**KIRKLEES METROPOLITAN COUNCIL  
DEVELOPMENT & MASTER PLANNING SERVICE**

**DELEGATED DECISION FOR PRIOR APPROVAL FOR CHANGE OF USE  
FROM COMMERCIAL, BUSINESS AND SERVICE USES TO  
DWELLINGHOUSES**

**Reference no. 2023/CL/91469/W**

**Site Address 2, 4 & 6, Thornton Lodge Road,  
Thornton Lodge, Huddersfield,  
HD1 3JQ**

**DWG NO.** 2304 - 01

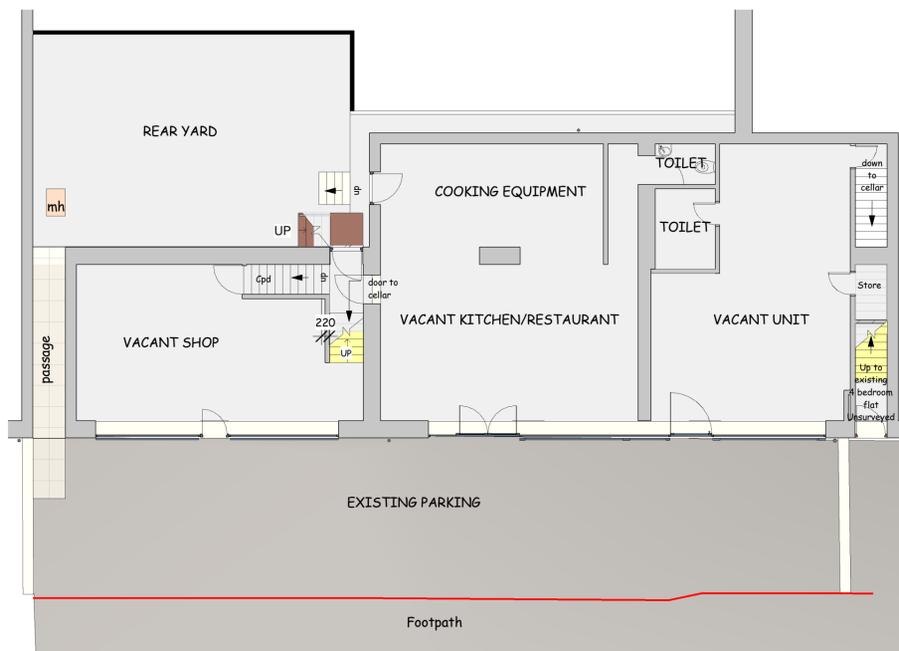
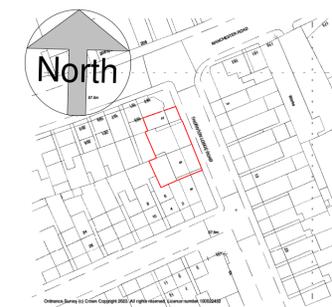
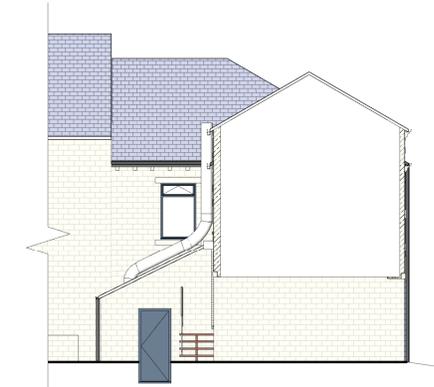
Living room – door opening with no windows although the current arrangement is not compatible with the proposed layout. If using the current frontage, light should be available for the living room.

- Incorrect red line boundary

Response: The area in question does not affect the outcome of the recommendation.

DWG NO. 2304 - 02

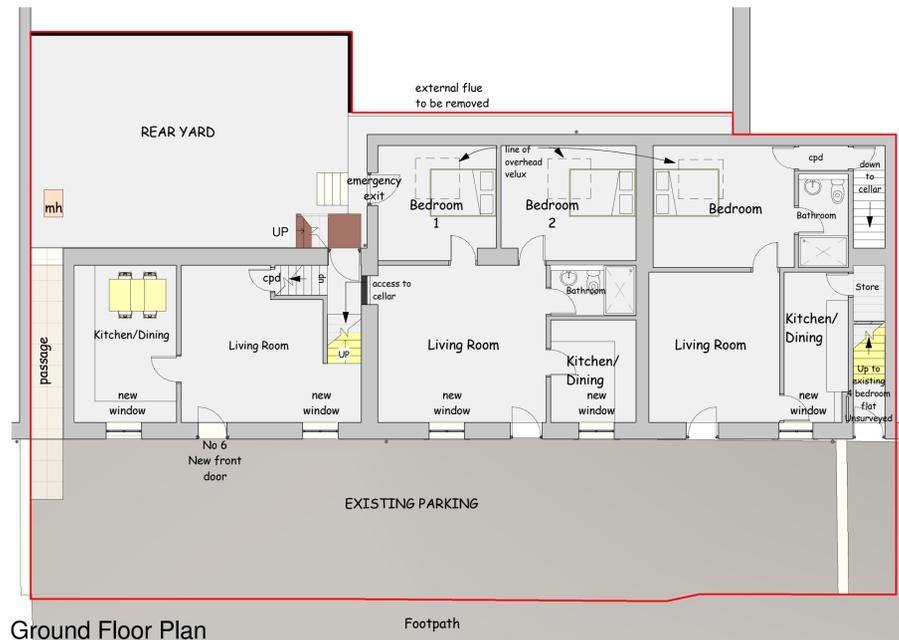
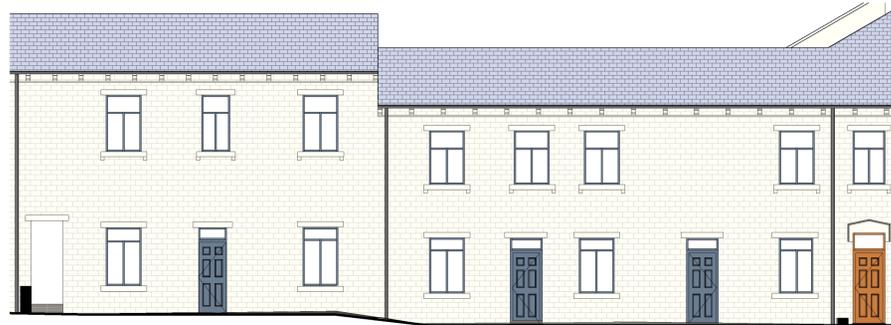
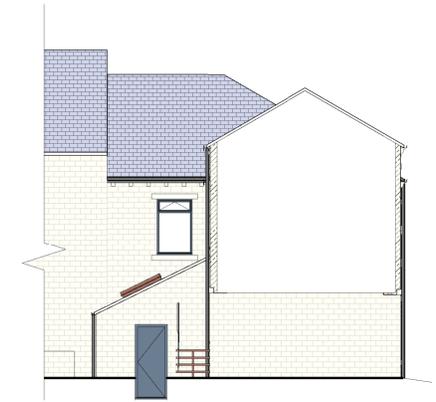
The proposed street scene elevation indicates that there would be alterations to the frontage of the building in terms of altering the existing fenestration details and the installation of roof lights to the rear single storey projection. These alterations would not be granted consent under this Class MA application and would require separate planning permission. Consequently the application must be assessed upon the building in its current exterior appearance.

(minimum assessed) on one storey should be at least 37 or 39 square metres dependant on whether the bathroom has a shower or a bath. In this instance the proposed internal accommodation proposed is approximately 48 square metres which would accord with the recommended space standards. However, the bedroom is shown to sleep two persons which requires 50 square metres of space thus contrary to space standards.

No. 4 is proposed to be a two bedroom ground floor flat. The Technical Housing Standards document states that a two bedroom flat for three persons over one storey (minimum assessed) should be at least 61 square metres and for four persons 70 square metres. In this instance the proposed internal accommodation proposed would be approximately 56 square metres and therefore falls short of the recommended space standards and therefore cannot benefit from a prior approval.

Bedroom – no windows other than roof light which currently does not exist and is likely to require planning permission.

In terms of this unit, due to the lack of openings to the bedroom under present arrangements, it is not considered that there would be adequate natural light to all habitable rooms.

Bedroom 1 – no windows other than roof light which currently does not exist and is likely to require planning permission.

Bedroom 2 – no windows other than roof light which currently does not exist and is likely to require planning permission.

With regard to this unit, it is considered that the current openings within the living room and kitchen/diner would provide adequate natural light to these habitable rooms. However, as with No. 2 due to the lack of openings to the bedroom under present arrangements, it is not considered that there would be adequate natural light to all habitable rooms.

The external alterations as shown on the proposed plan for no.2 & no.4 do not benefit from any planning permission and the provision set out in Class MA, Part 3 of Schedule 2 of the Town and Country Planning (General Permitted Development)(England) Order (as amended) do not provide for such permission either. Consequently the assessment of natural light is taken under current fenestration arrangements for each proposed dwellinghouse. Therefore all bedrooms in no. 2 & no.4 lack any natural light and are therefore contrary to paragraph MA.2 (2)(f) of Class MA.
